Project#1008630 Manzano Mesa Tract(s) C
13DRB-70741 Preliminary/Final Plat Approval

9. **Project# 1008630**
13DRB-70682 MINOR - PRELIMINARY/
FINAL PLAT APPROVAL

RE: Tract C, Manzano Mesa

PLAN VIEW - PUBLIC DRAINAGE EASEMENT AND PUBLIC UTILITY EASEMENT

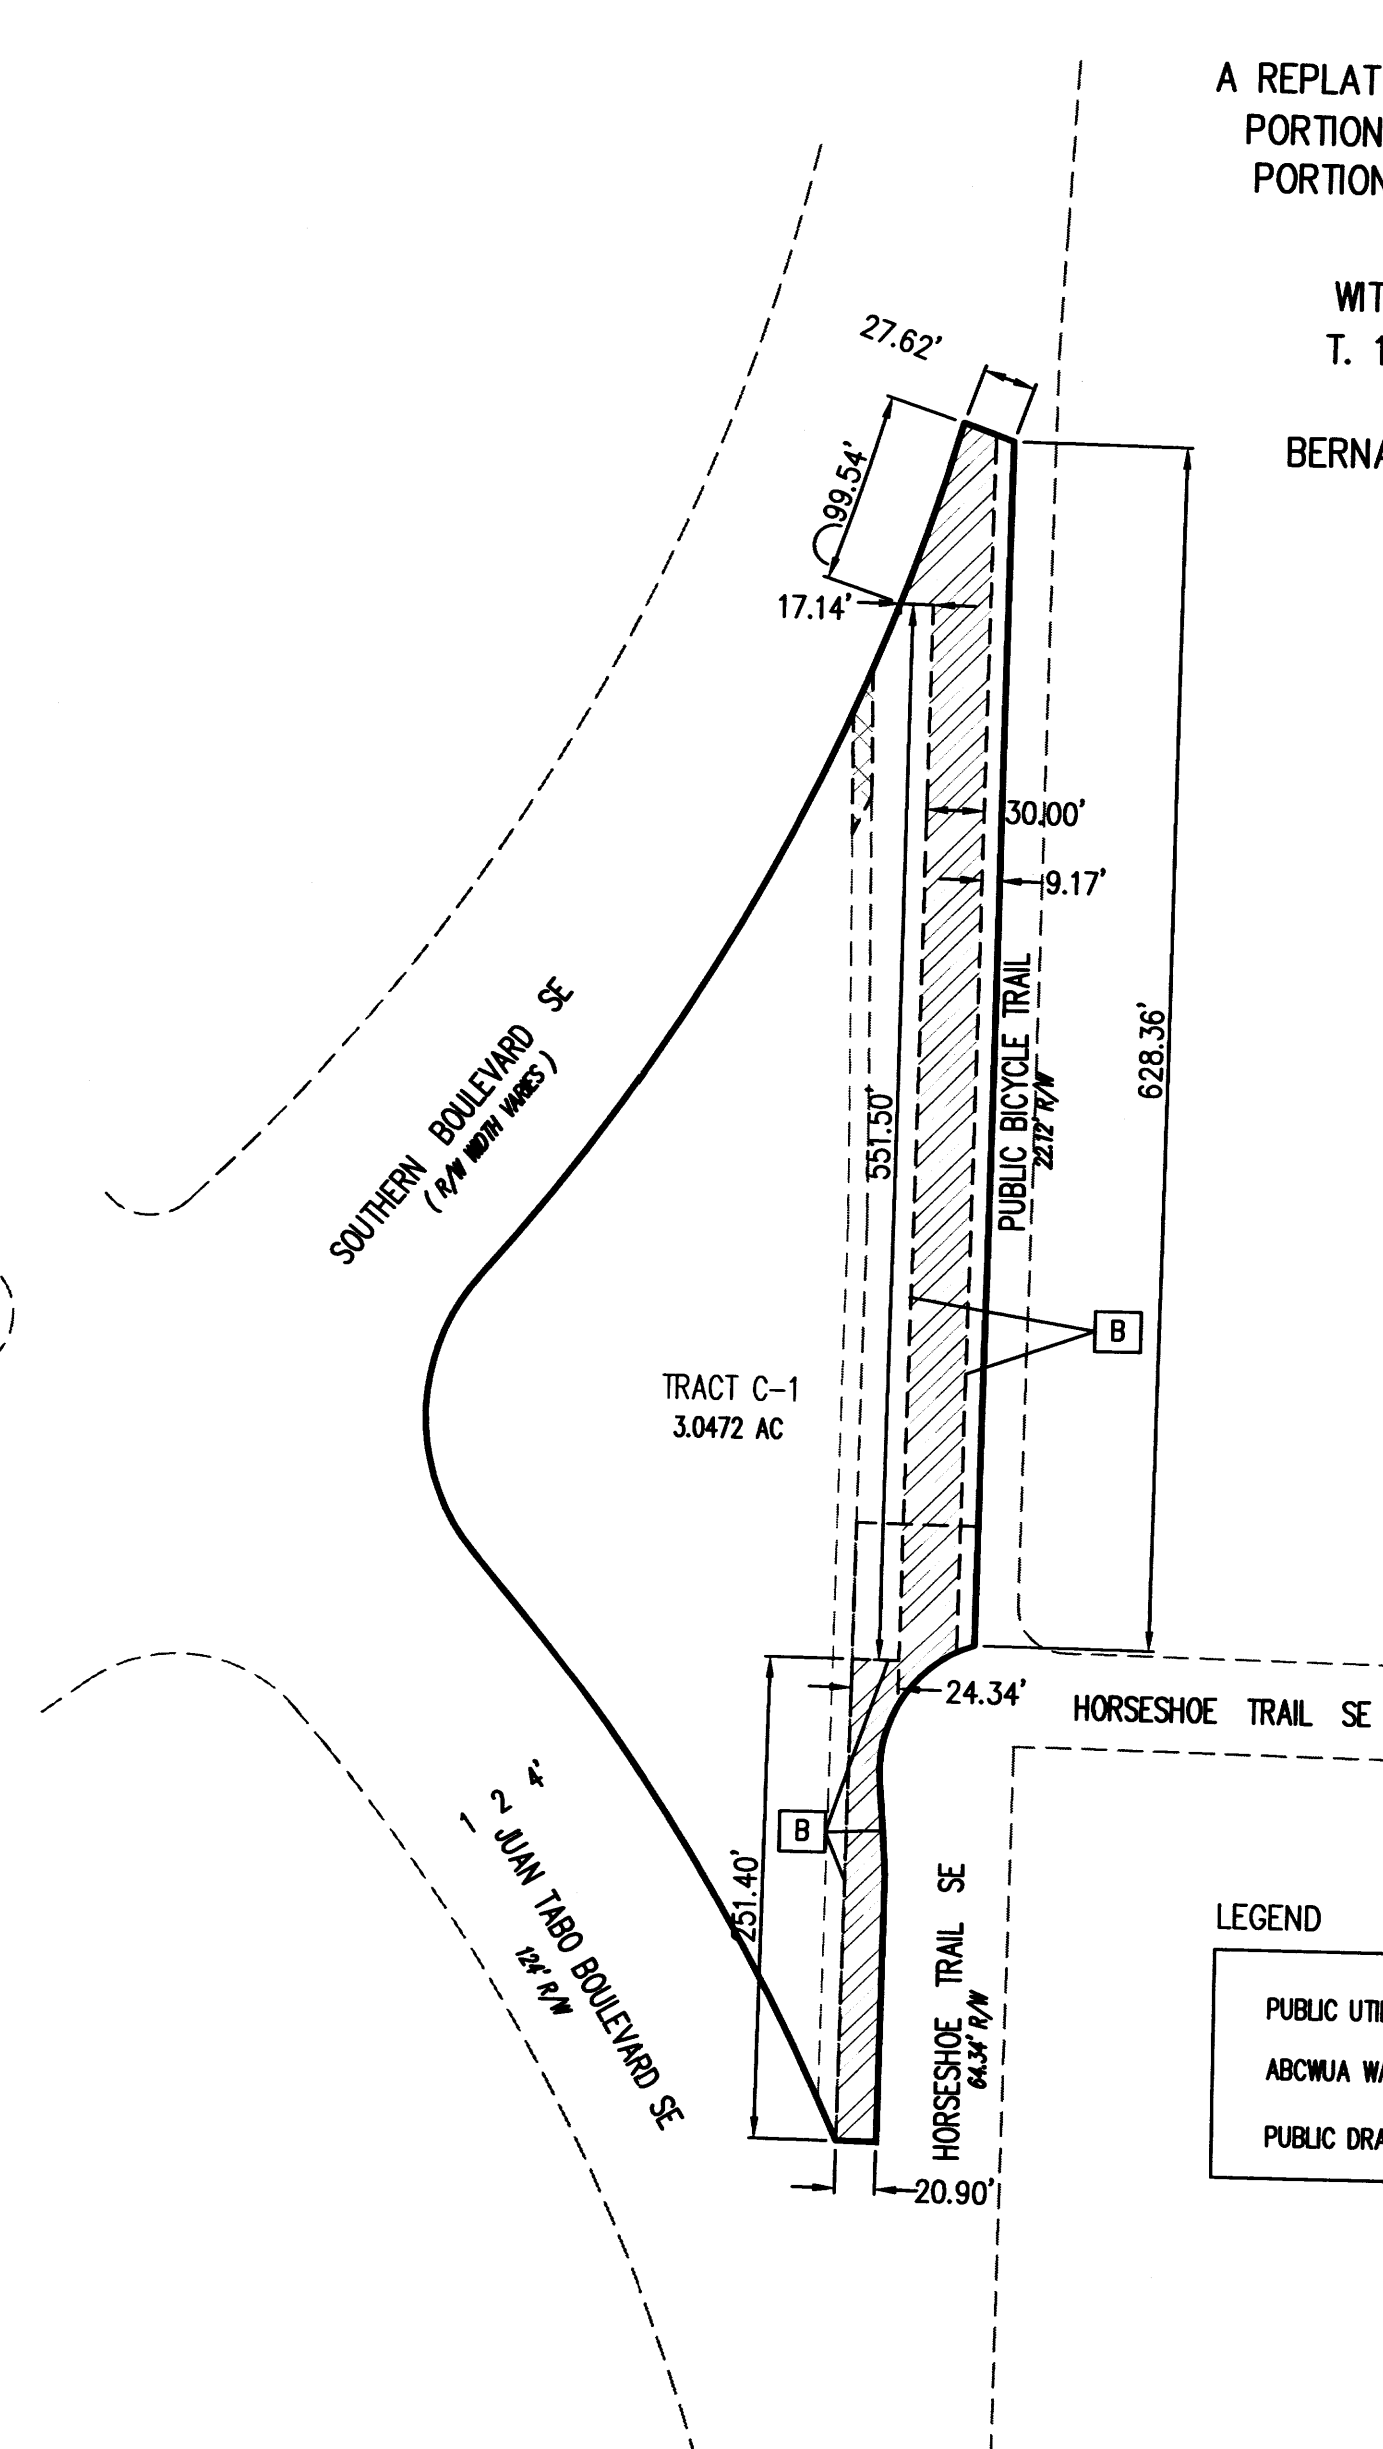
Proposed plat does not conform to Sketch Plat – the City does not normally leave a portion of right of way. More information/ field data is needed, plus a written commitment from DMD for maintenance of proposed Bike Trail right of way. Real Property must sign the plat to acknowledge disposition of vacated right of way.

Plat boundary lines do not clearly show existing tract, and the legend does not distinguish between Disclosure Statement (?) 2 and 3, or 4 and 6.

SITE SKETCH FOR TRACT C-1 MANZANO MESA

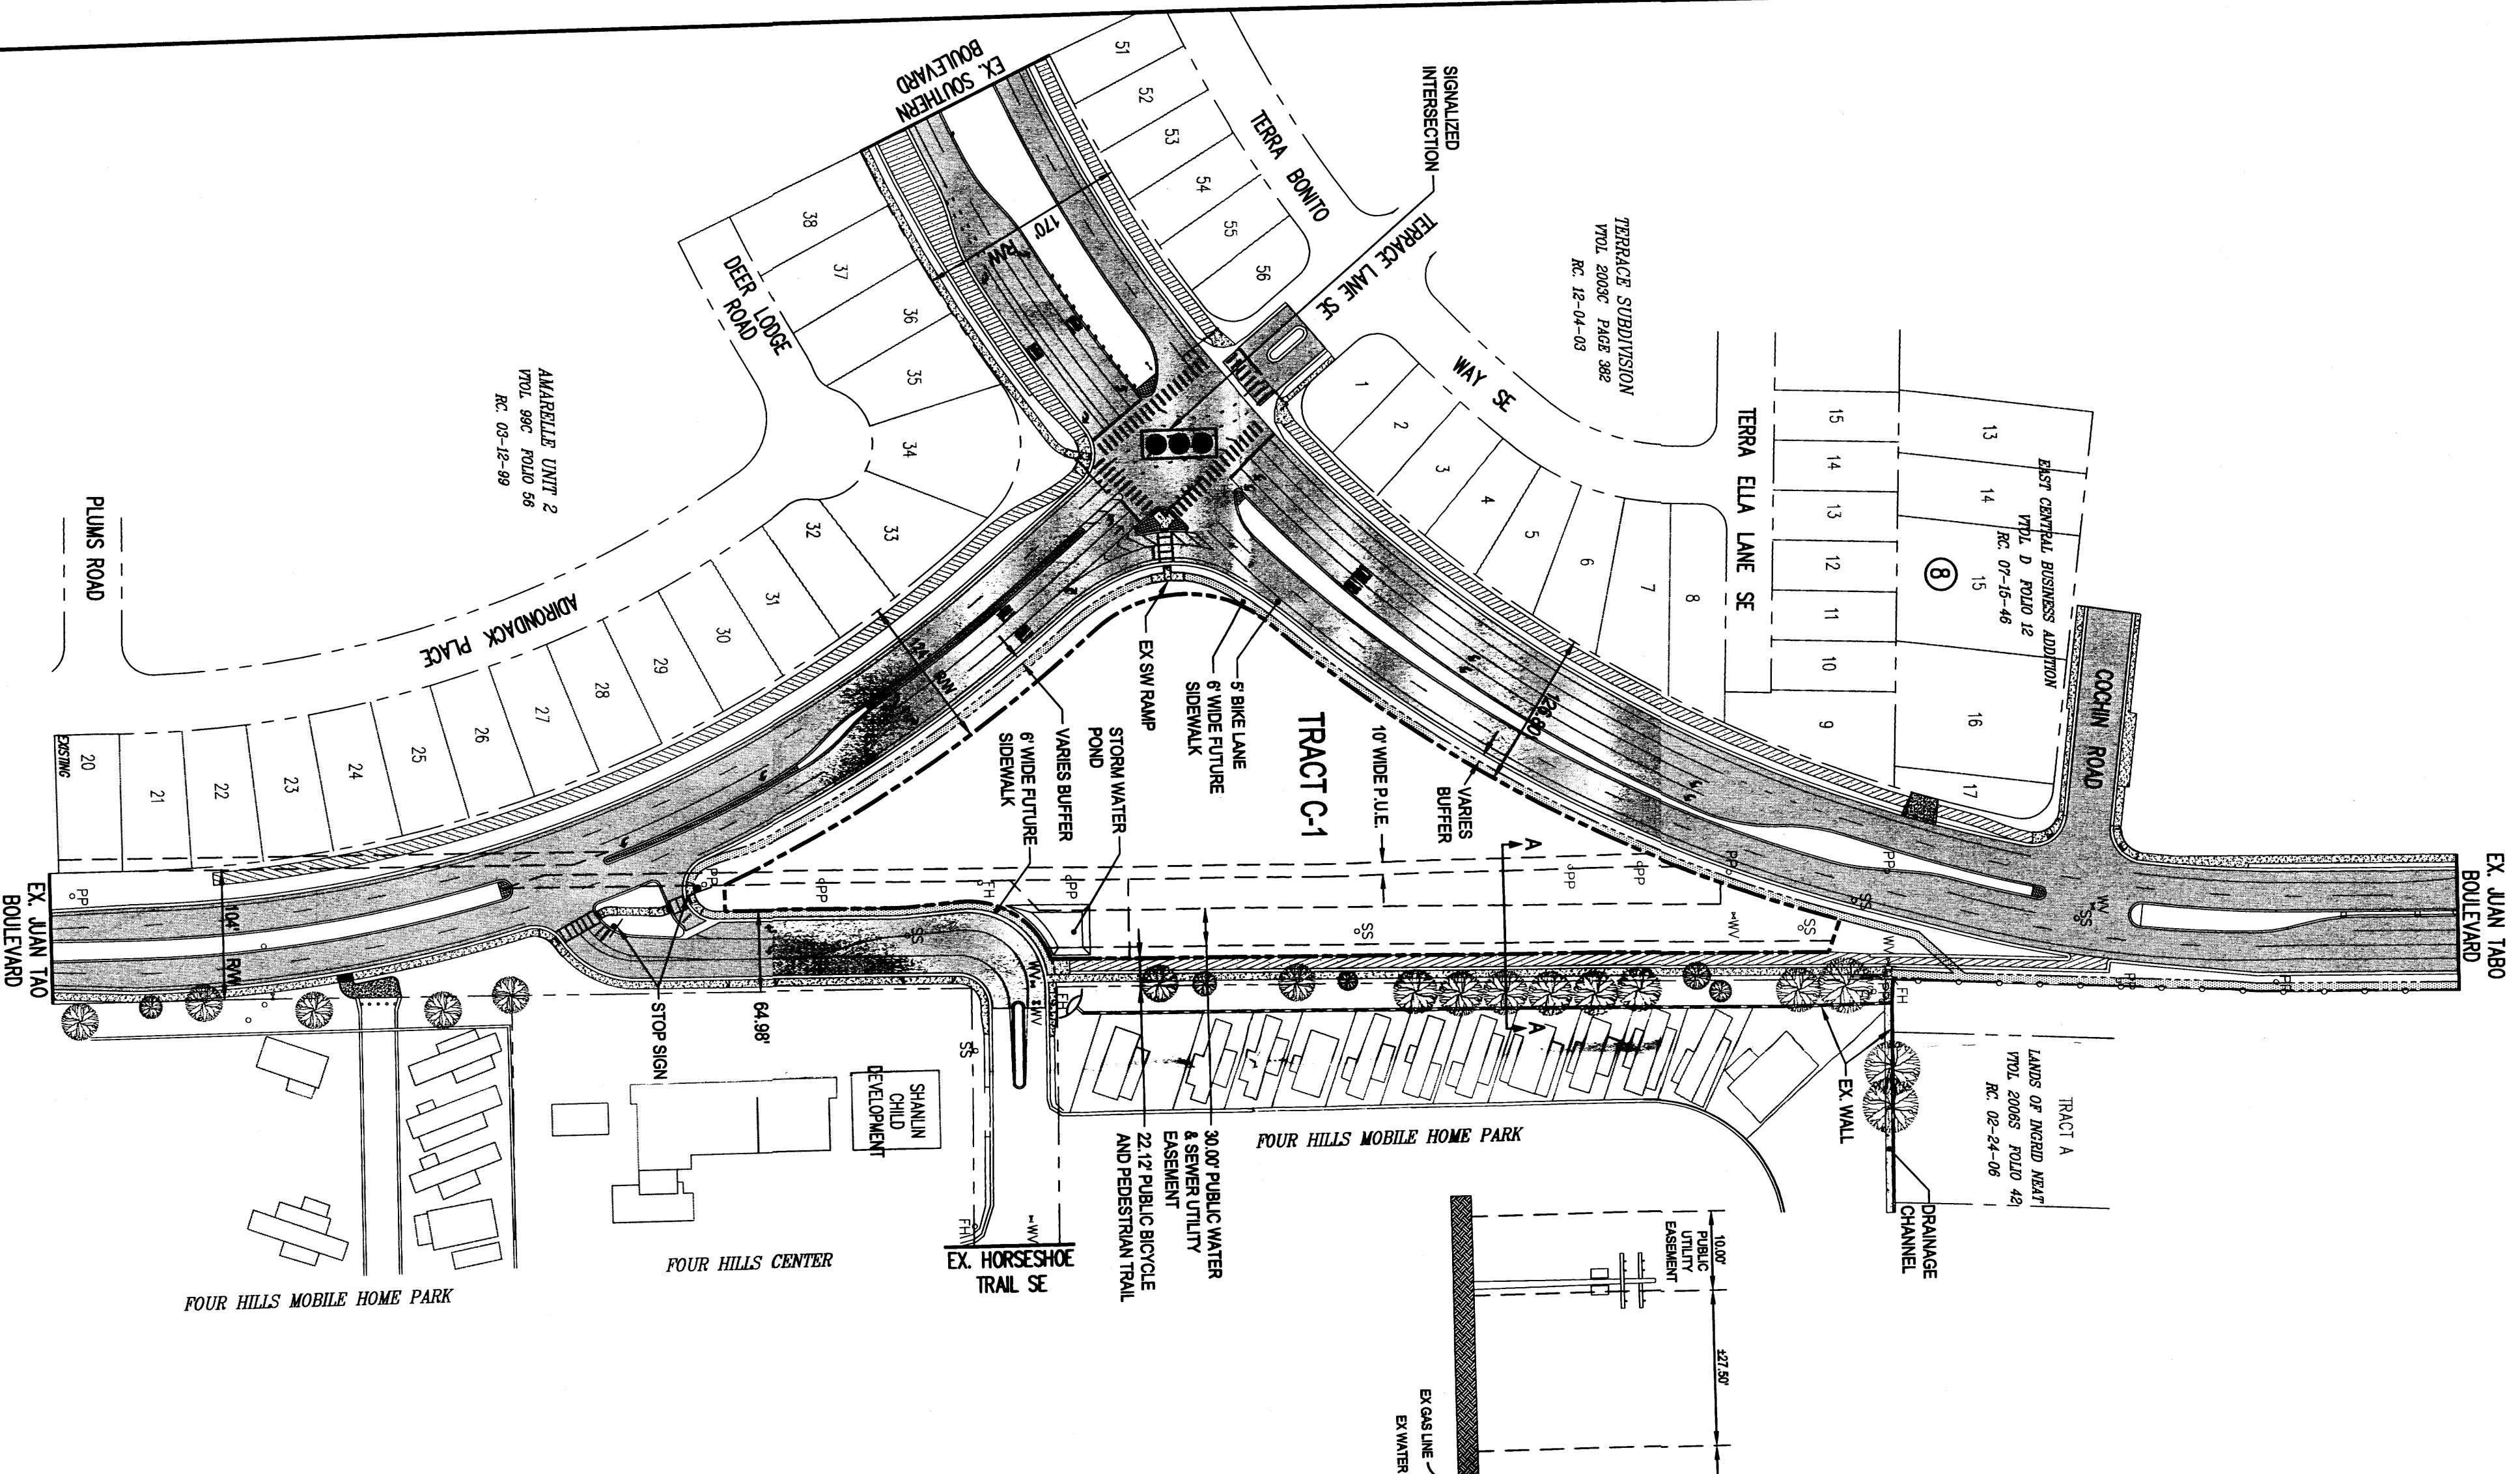
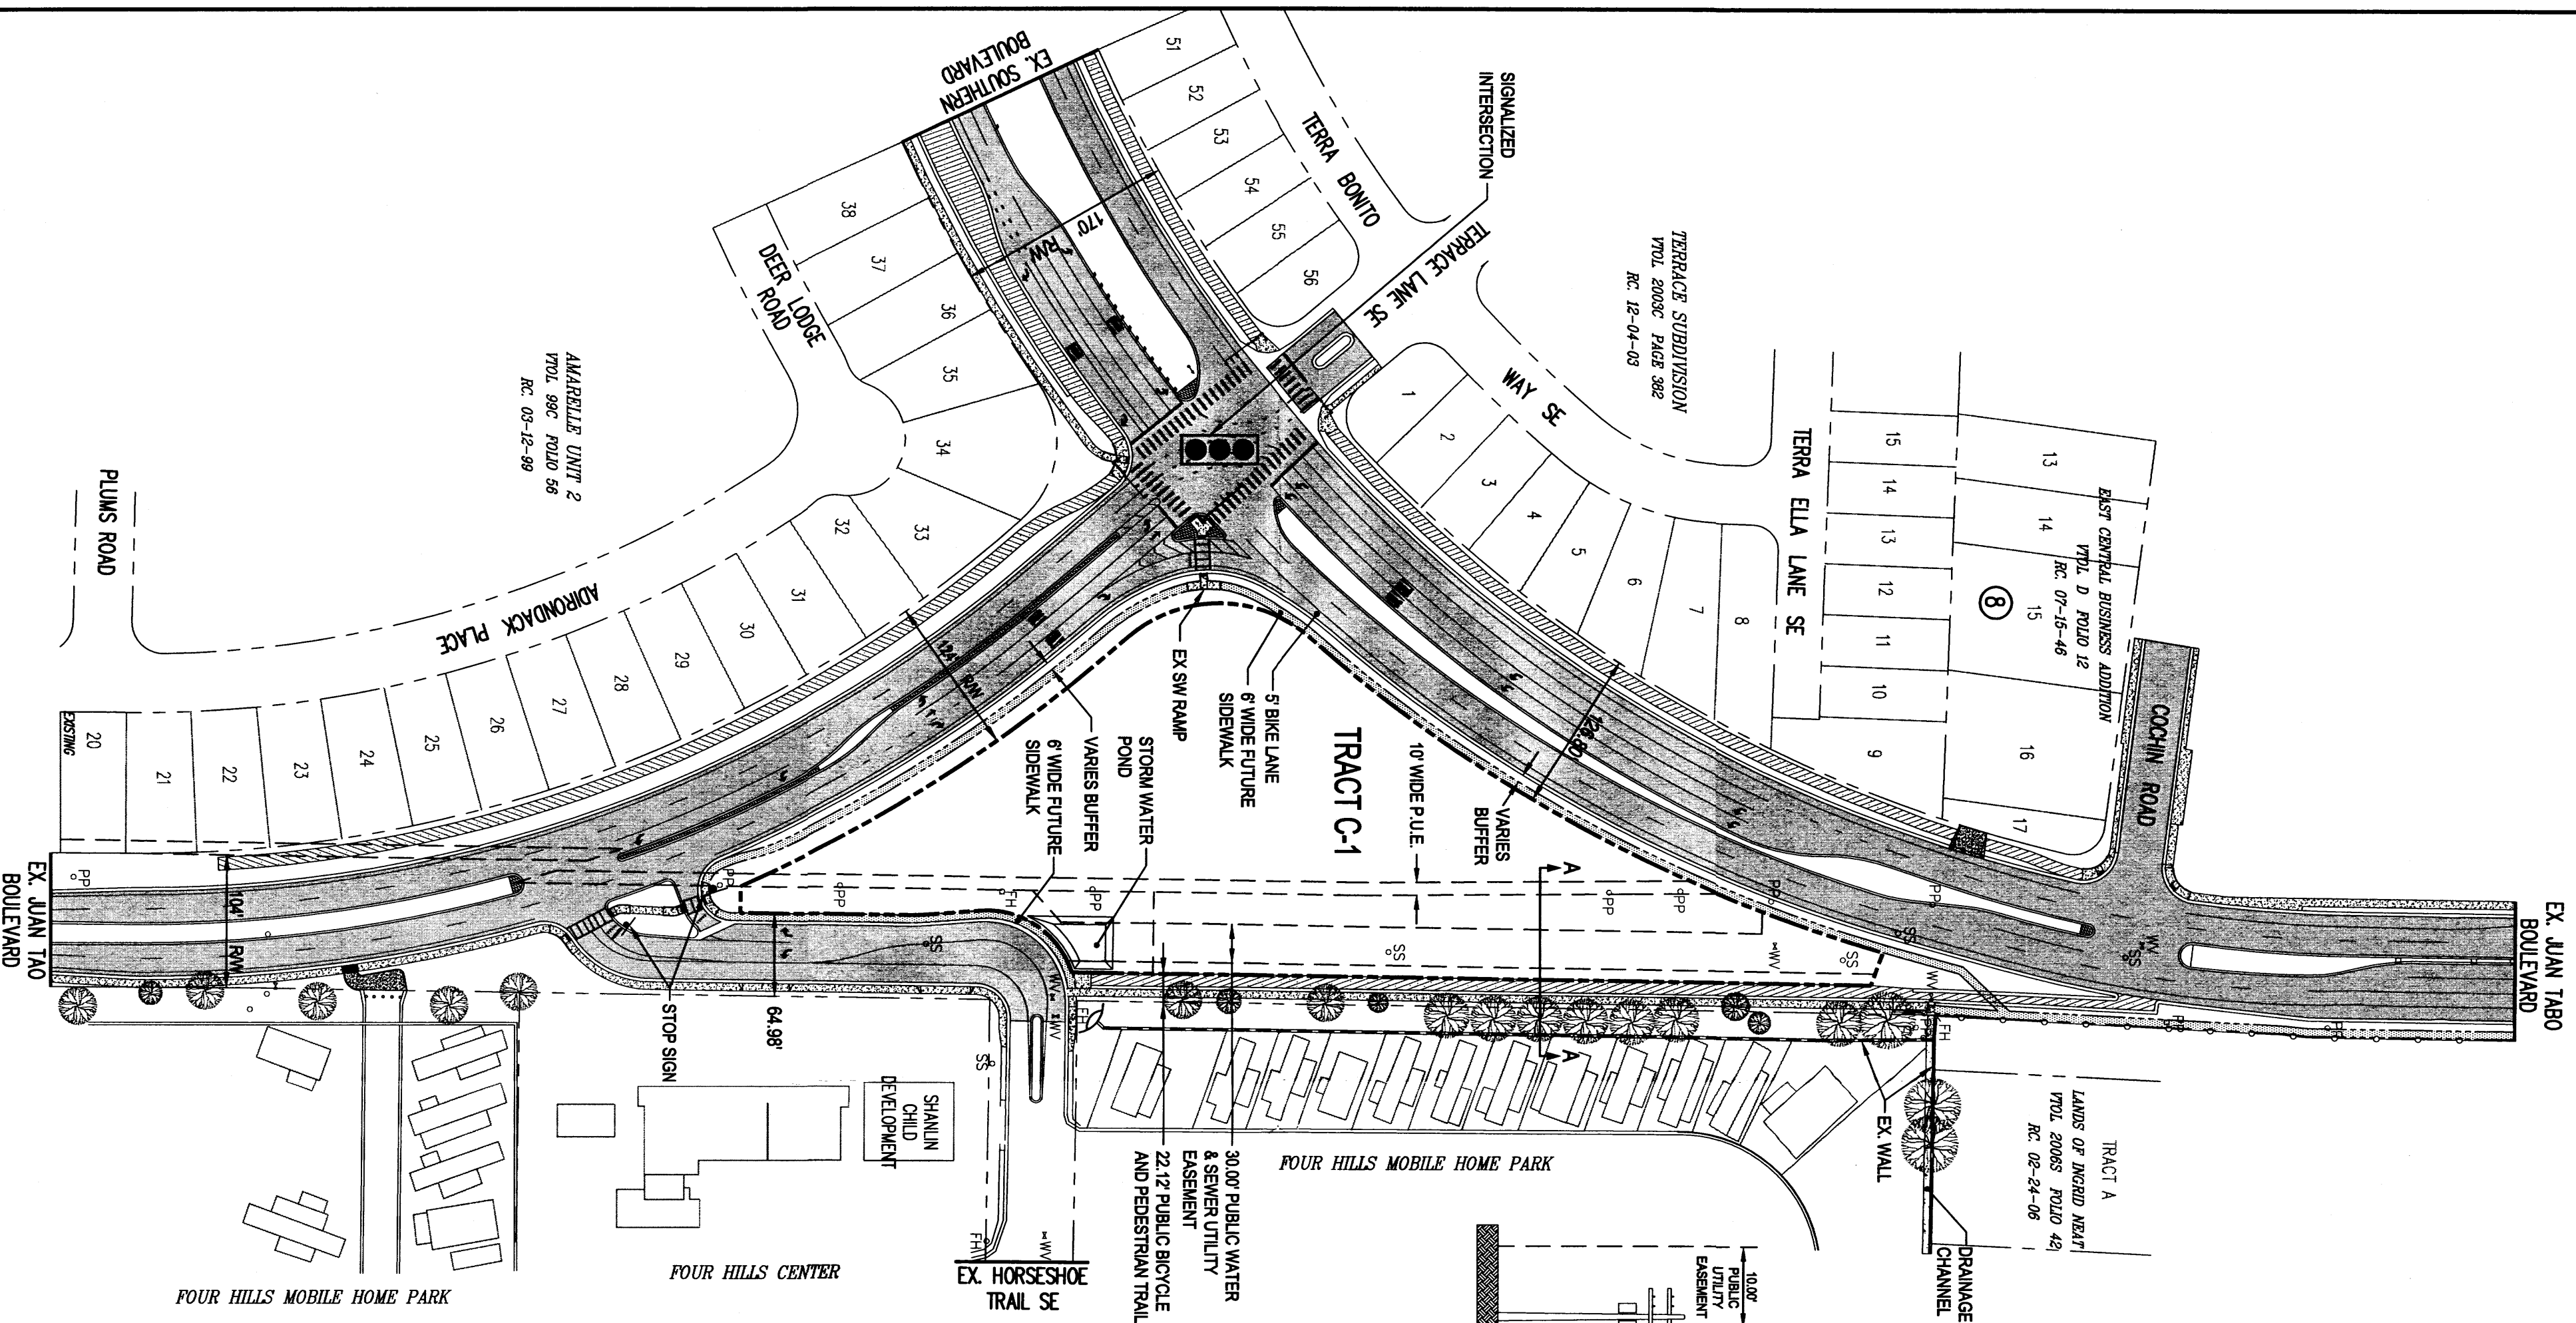
Provide an exhibit showing the location of sidewalk and defining the distance from back of curb to the property line. Right of way dedication may be required.
The site sketch is unclear; clarify existing versus proposed sidewalk.
